# **KIRKLEES METROPOLITAN COUNCIL INVESTMENT & REGENERATION SERVICE**

| Reference No:         | <b>2025/62/91650/E</b>                                                                                          |
| Site Address:         | 143, Upper Commercial Street, Batley, WF17 5DH                                                                  |
| Description:          | Change of use of former public house (sui generis) to House in Multiple Occupation (within a Conservation Area) |

Proposed First and Second Floor

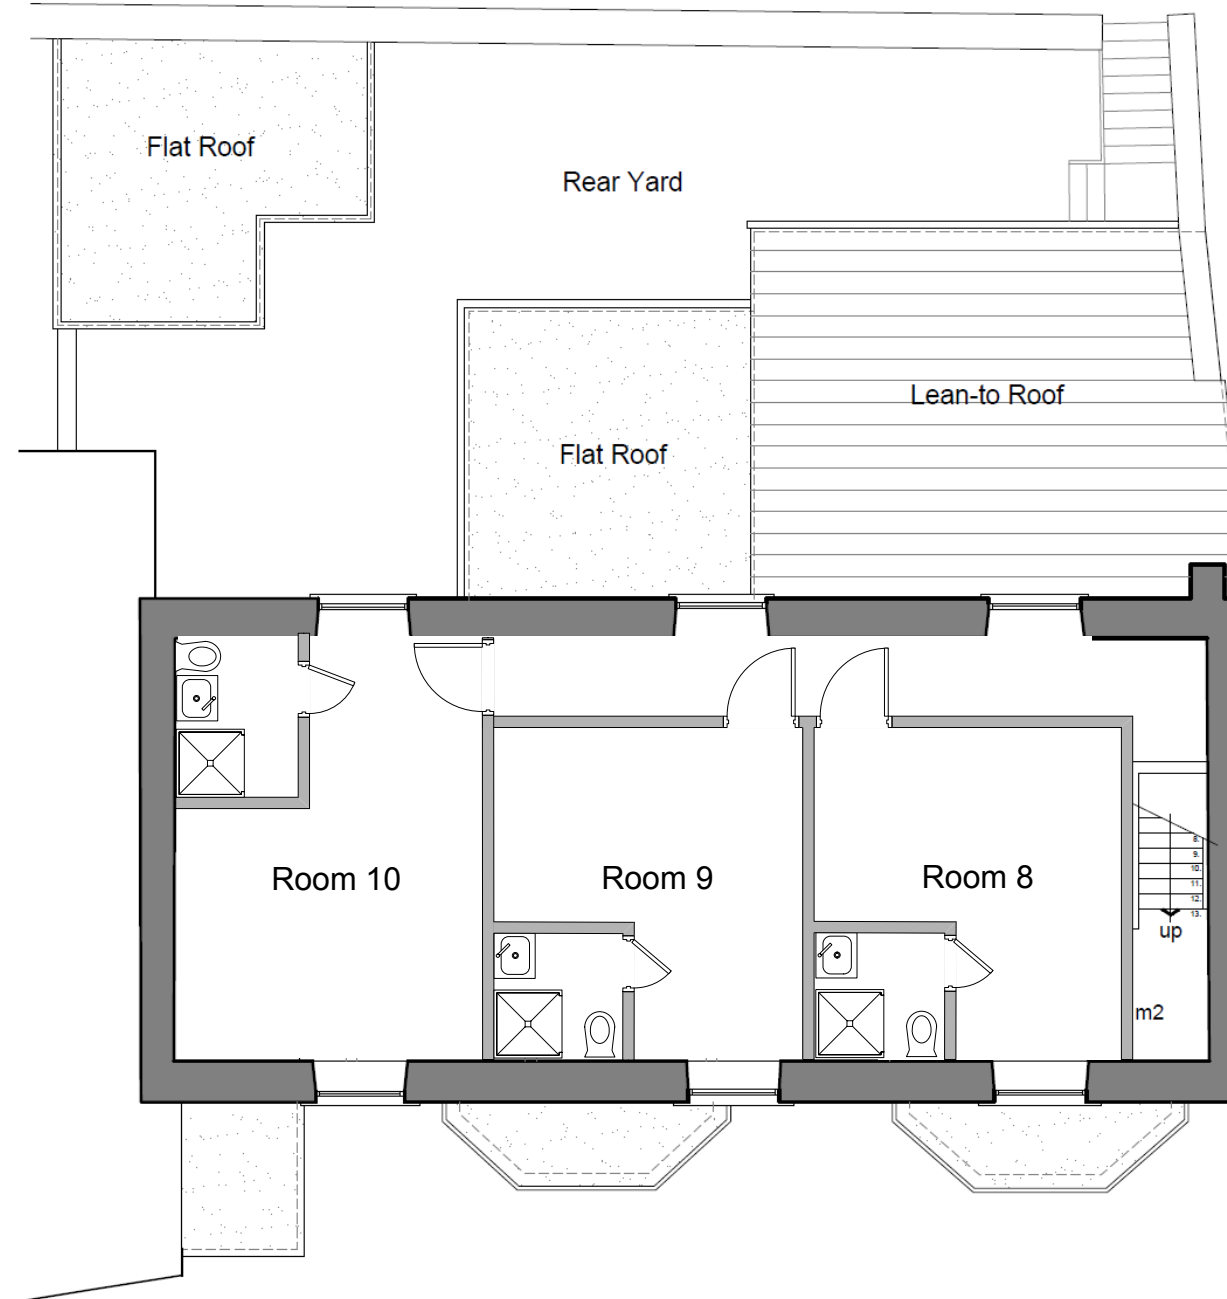
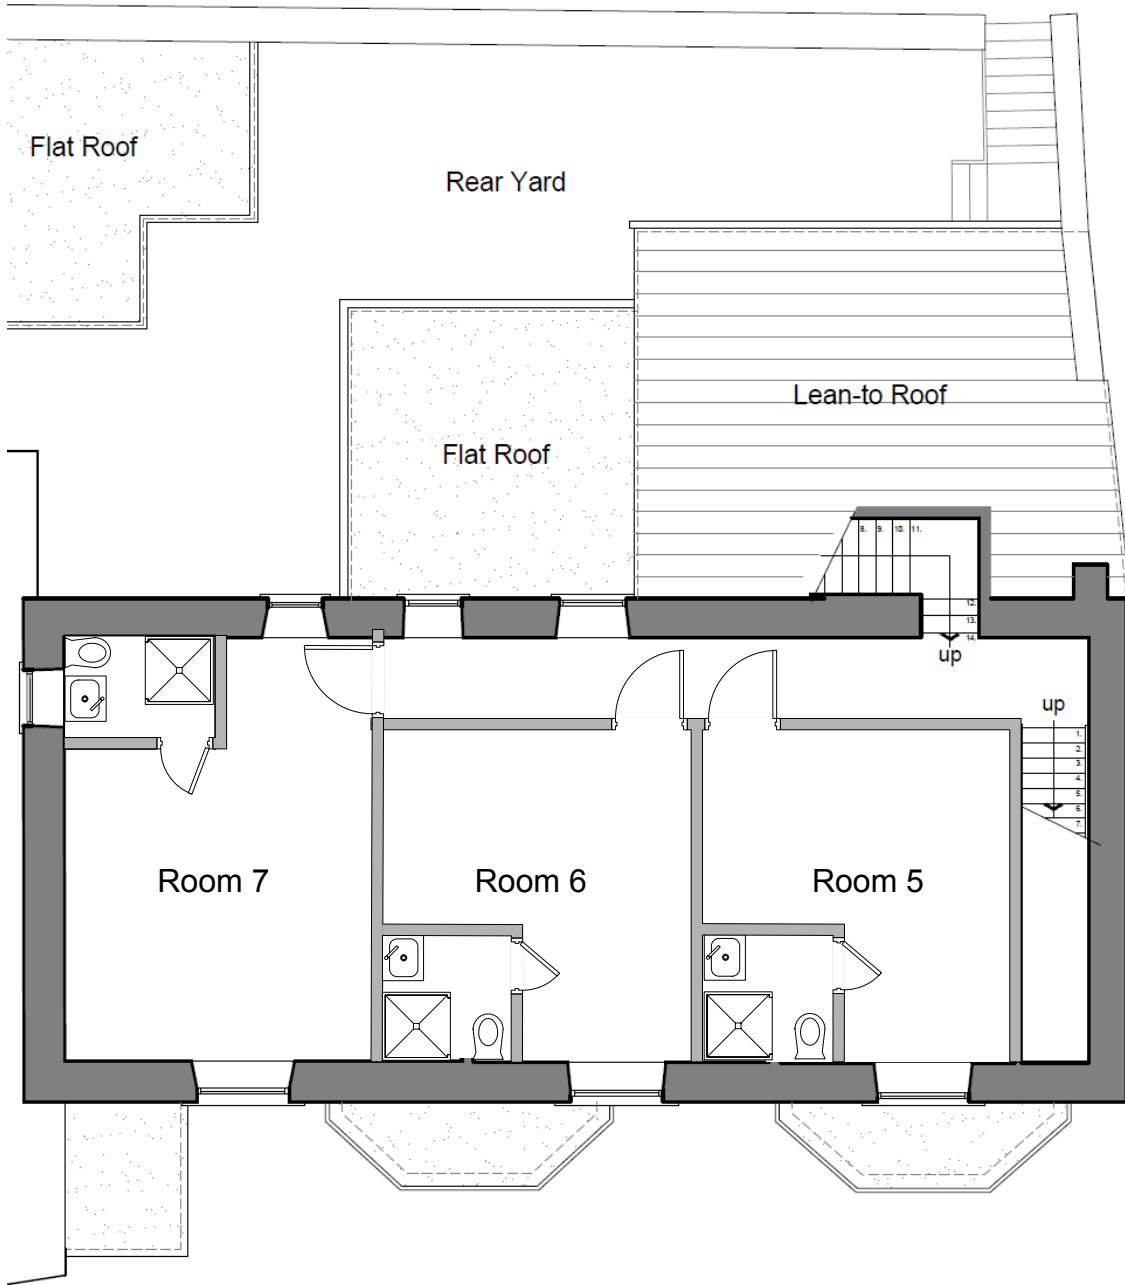
Section 8.1 of this document refers to bedsits and flats. This states that where one unit of accommodation has cooking living and sleeping facilities in one room one person should have an area of 13m<sup>2</sup>, where the occupants would have two or more rooms within cooking, living and sleeping facilities, a single bedroom should have an area of 6.5m<sup>2</sup> and a double room should have an

Section 8.2 refers to shared accommodation states that each living room should have a minimum floor space of 8m<sup>2</sup> plus an additional 1m<sup>2</sup> for every person in the building. The proposal would be 1.7m<sup>2</sup> smaller than that specified amount.

Officers have reviewed the details submitted, it is acknowledged that the shared community area would be 1.7m<sup>2</sup> smaller than outlined in the HMO amenity standards; however, it is noted that all bedrooms would meet the minimum requirements, they all benefit from private bathrooms which have not been included in the floor space calculations for the room and there is private amenity space associated with the building to the rear. It is therefore considered on balance that the 1.7m<sup>2</sup> shortfall in relation to shared communal space is acceptable in this instance

- 6. The number of bedrooms of the use hereby approved shall not exceed 10.no in total.

Site Layout Plan Proposed

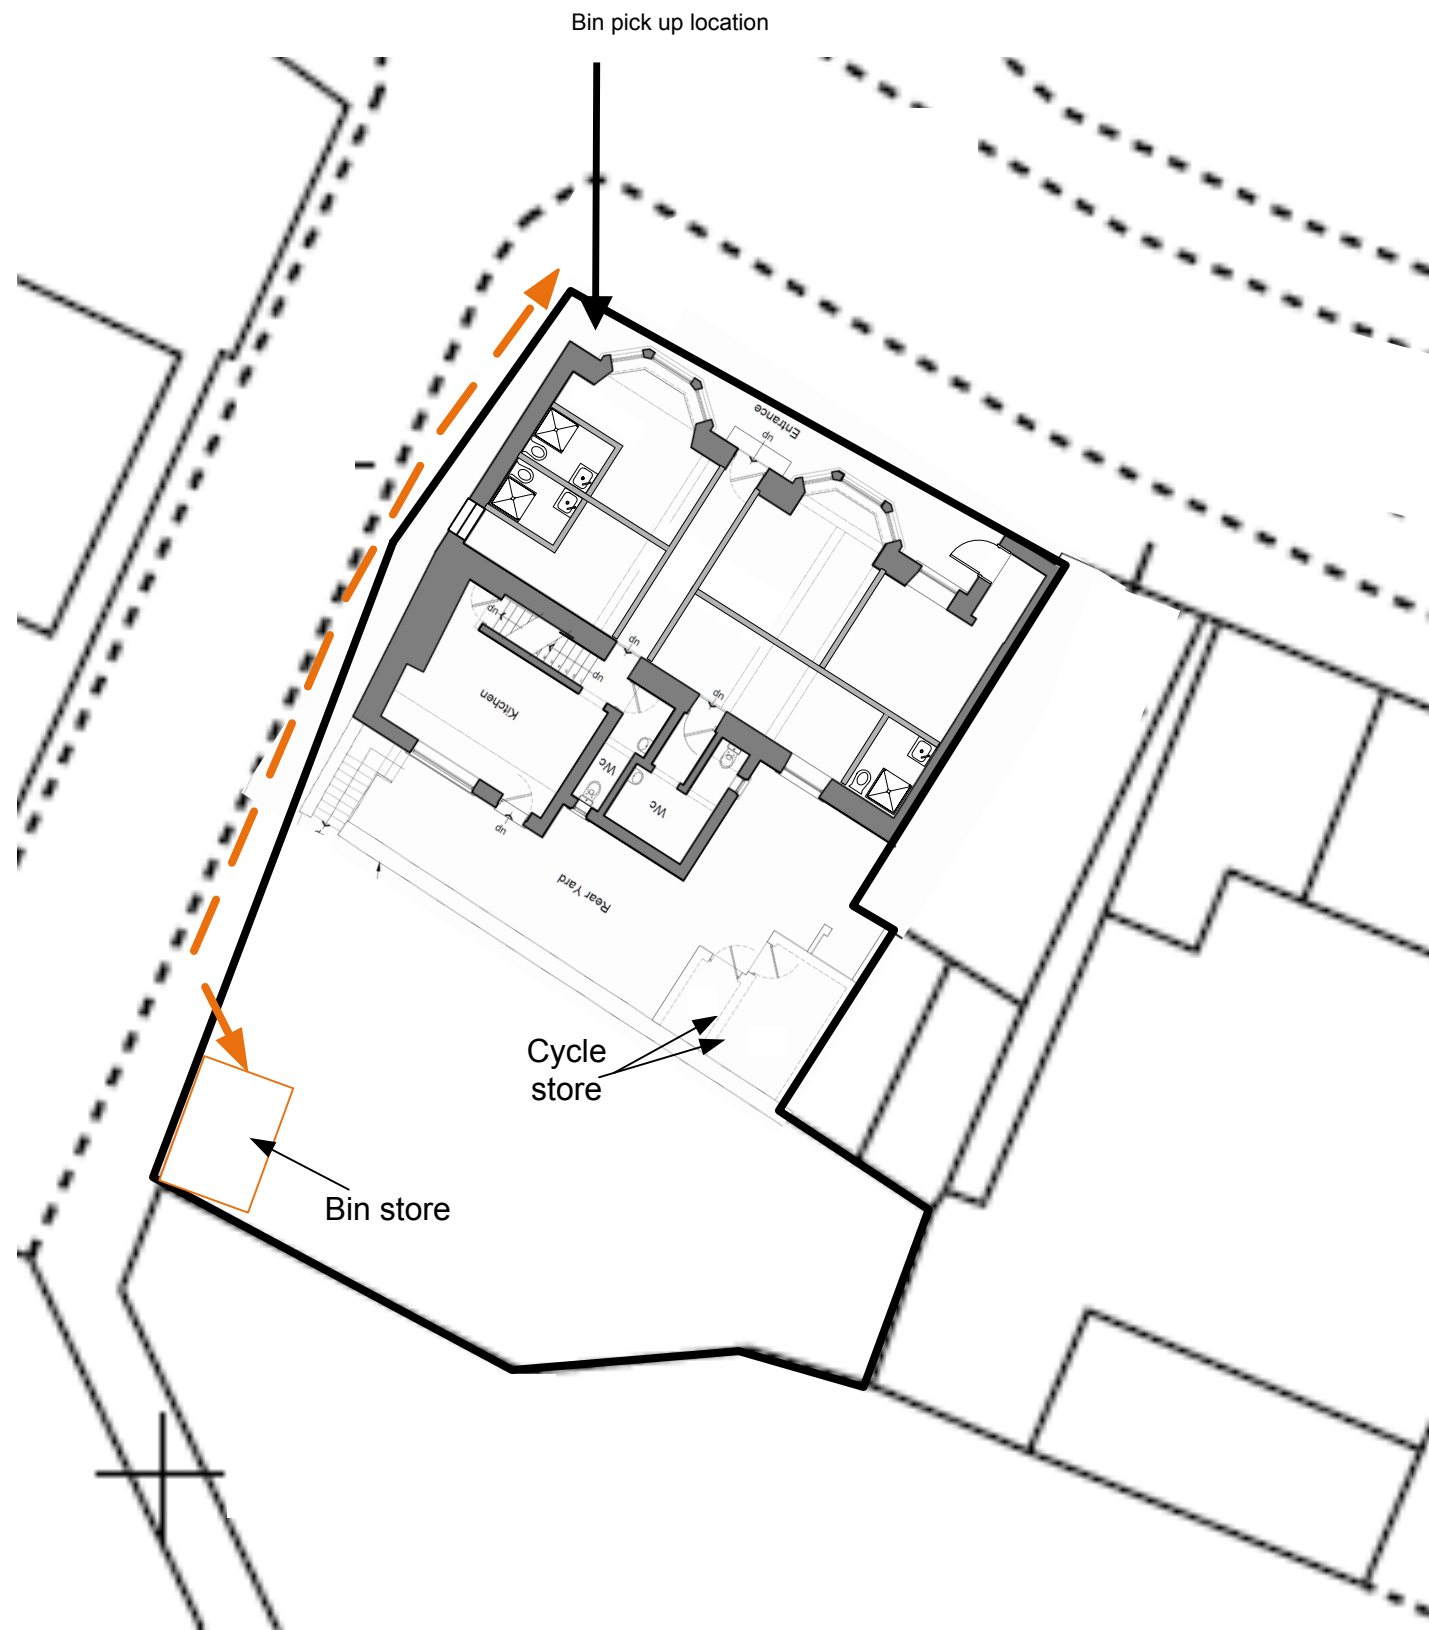
Officers requested for alterations to be made to the floor plan of the proposal during the application due to concerns relating to the amenity space of future occupiers. In addition, the location of the bin storage and presentation points was requested to be amended due to the initial locations not being considered

**KC Highways Development Management** – Informal discussion, requested details of bin storage and collection details to be amended.

There has not been a highway statement provided to support the application; however, discussions have been held with KC Highways. KC Highways reviewed the application requested details of bin presentation points were required. It is considered that the site is in a sustainable location and therefore the provision of parking is not essential in this instance.

3. Before first occupation of any of the residential units hereby approved, the storage and access for collection of wastes from the premises shall be implemented in accordance with the details shown on drawing number UCS006revB titled 'Site Layout Plan Proposed' shall be provided and thereafter retained
